WEST SUSSEX COUNTY COUNCIL CONSULTATION

TO:	Arun District Council FAO: Richard Castro-Parker
FROM:	Highways, WSCC
DATE:	06/02/2019
LOCATION:	324 Chichester Road, Bersted, West Sussex
SUBJECT:	BE/81/18/PL Change of use of the property from dwellinghouse to mixed use dwellinghouse & attached building for the operation of a hairdressing business (A1) & retention of attached building
DATE OF SITE VISIT:	N/A
RECOMMENDATION:	☒ Advice ☐ Objection ☐ Modification ☐ No Objection ☐ More Information ☐ Refusal
S106 CONTRIBUTION TOTAL:	£N/A

Drawing 3 - Proposed Site Plan
Scale 1:200 @ A3

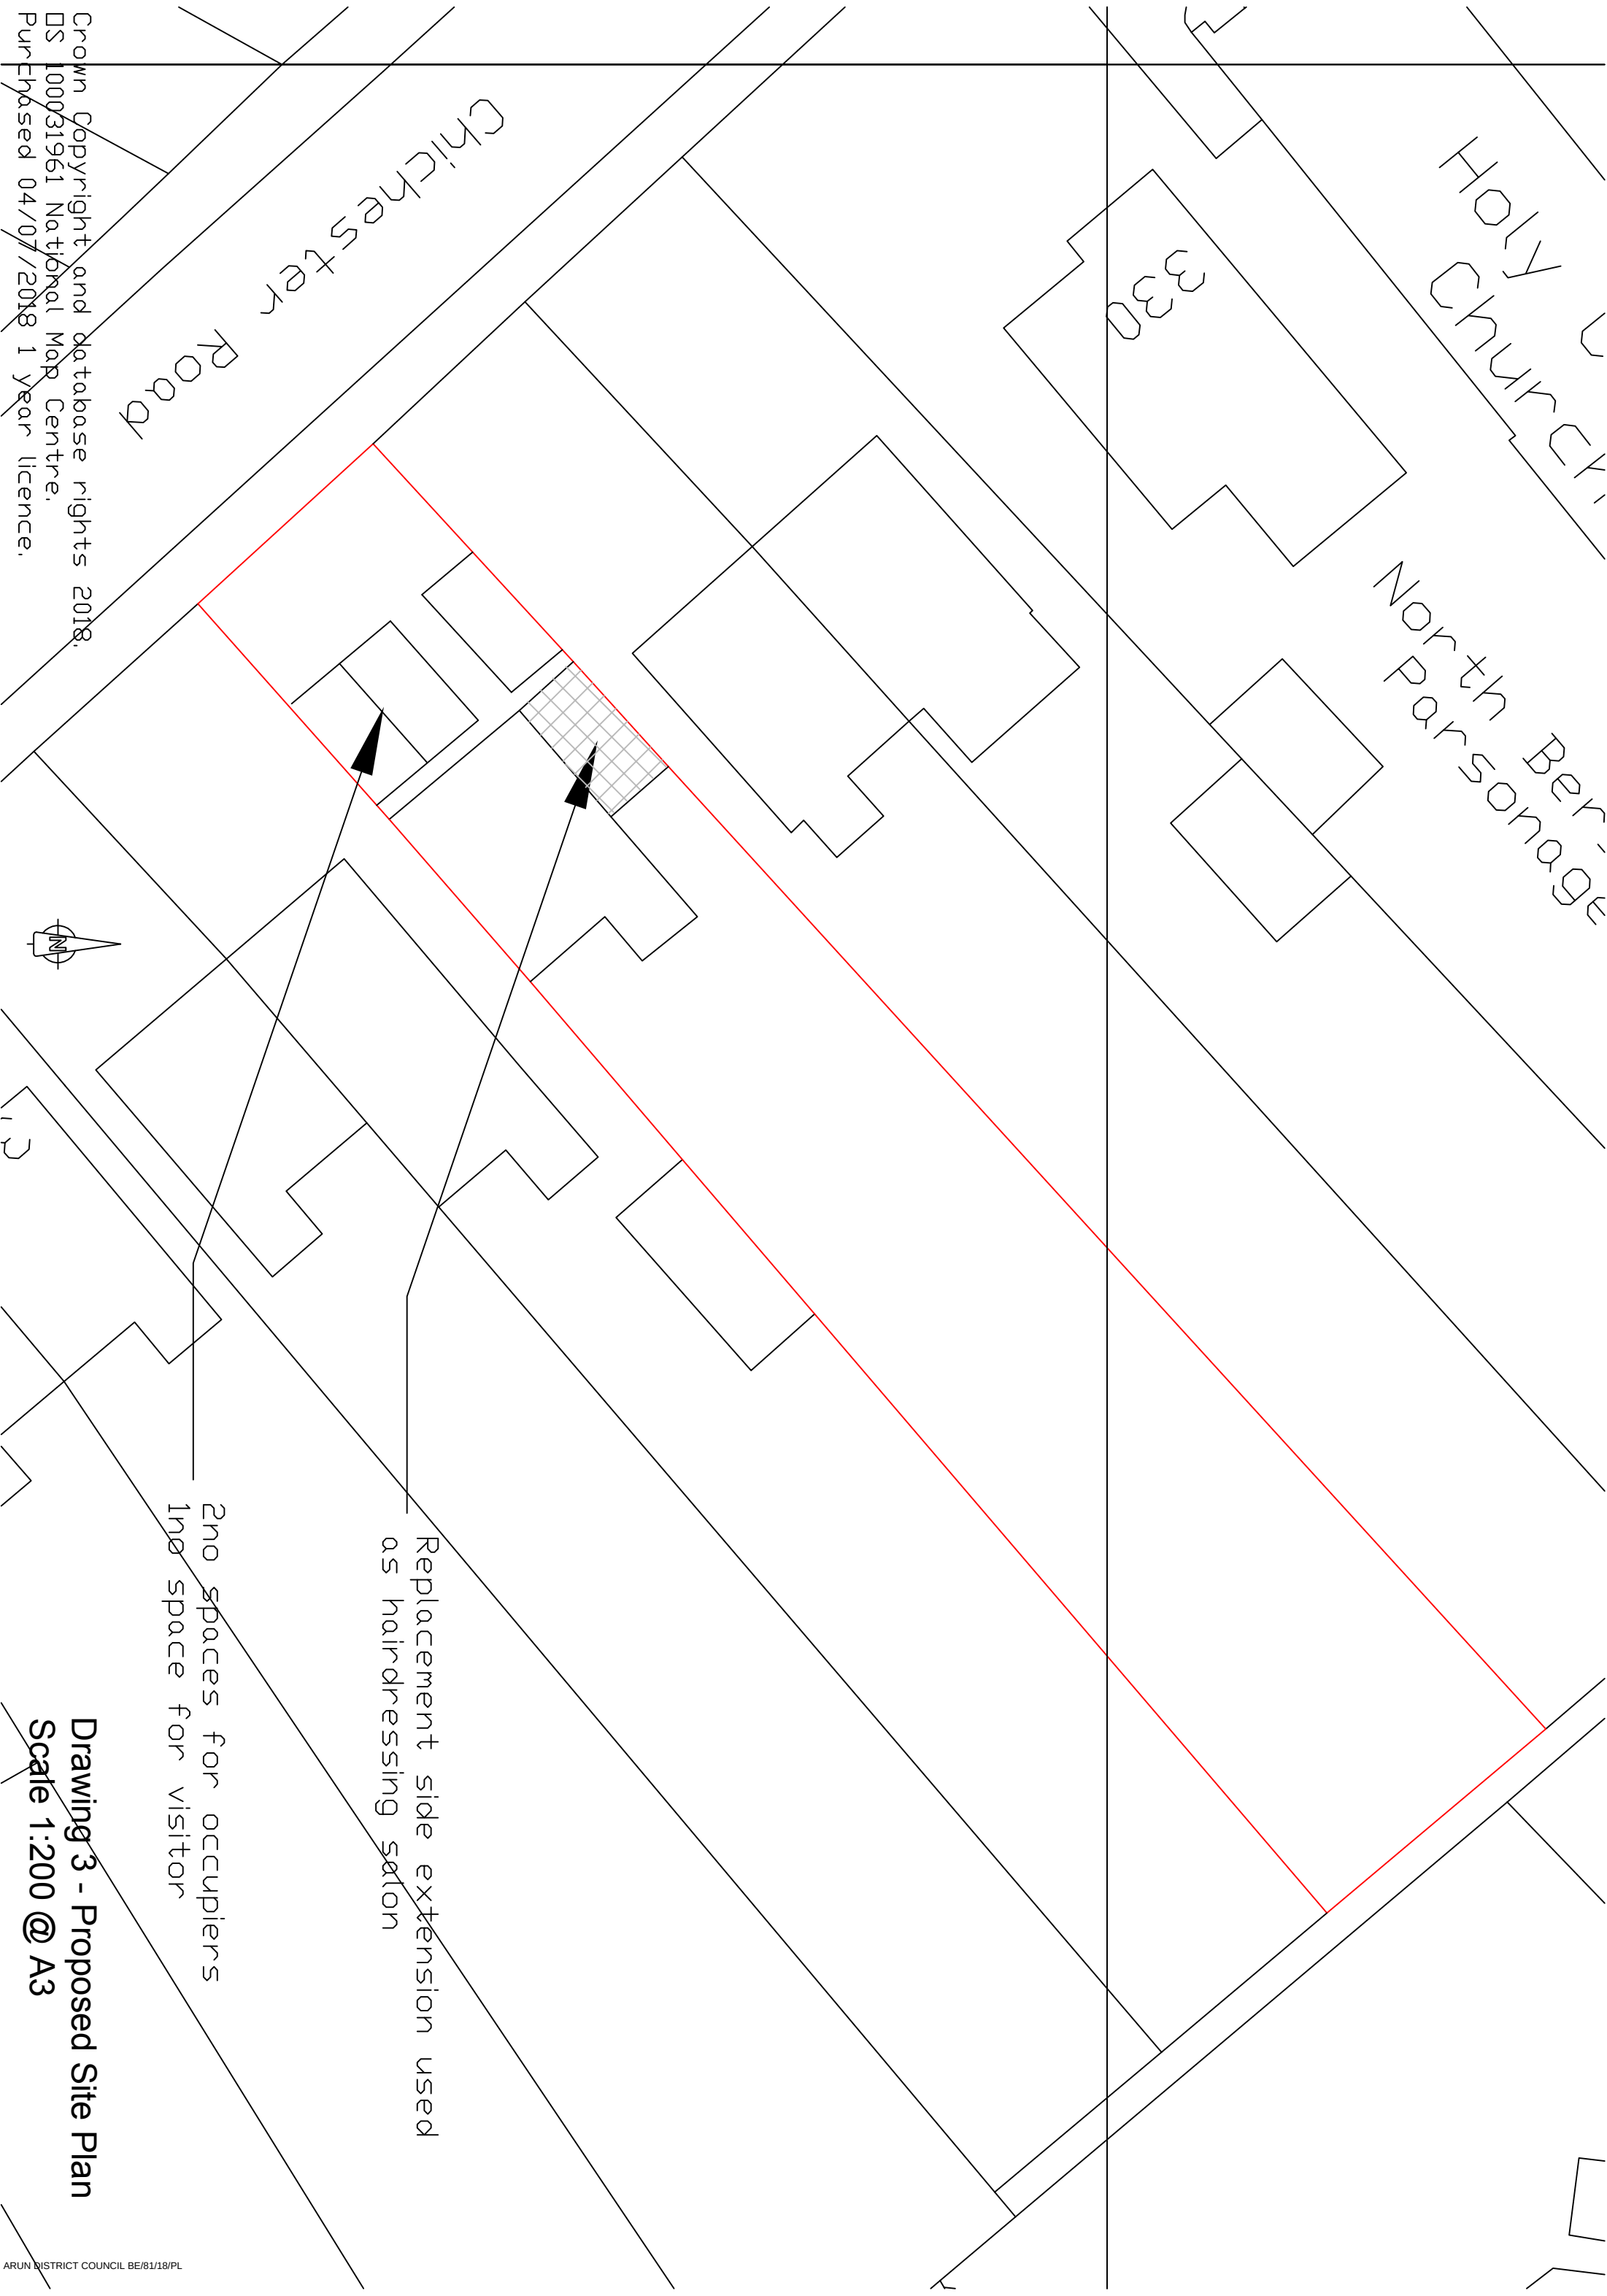
The applicant proposes to utilise the existing driveway for customer parking. A parking layout plan has been provided, demonstrating two parking spaces for the residential use and one parking space for the proposed hairdressing use. WSCC mapping indicates that there is sufficient space on site for three cars to park. The proposed parking provision is anticipated to be sufficient given the nature of the business serving one client at a time. The situation may arise where the next customer arrives prior to the previous customer departing. It appears possible that in this case, a vehicle could park on site; however this would block in either the previous customer, or the residential vehicles. As a result some overspill parking may occur on-street. Although this part of Chichester Road does not benefit from parking restrictions, illegal parking could be dealt with as an offence under Section 22 Road Traffic Act 1988 –(leaving vehicles in a dangerous position on the road including verge/footway) and Section 137 Highways Act 1980 (wilful obstruction of the free passage along a highway.) Both of these acts are enforceable by Sussex Police. The LPA may wish to consider the potential impact of additional on-street parking from an amenity point of view.

Local mapping indicates that the frontage of the site is currently only partially laid to hardstanding. The applicant is advised to ensure that the entire proposed parking area is laid to hardstanding to prevent spillage of mud or loose material onto the public highway.

A turn on site would be preferred for the hairdressing and residential use, however this is an existing practice that has operated on site, and within neighbouring properties for some time without evidence of highway safety concern. This proposal is not anticipated to result in a material increase in vehicle movements to or from the site.

No part of the development shall be first occupied until the car parking spaces have been constructed in accordance with the approved site plan. These spaces shall thereafter be retained at all times for their designated purpose.
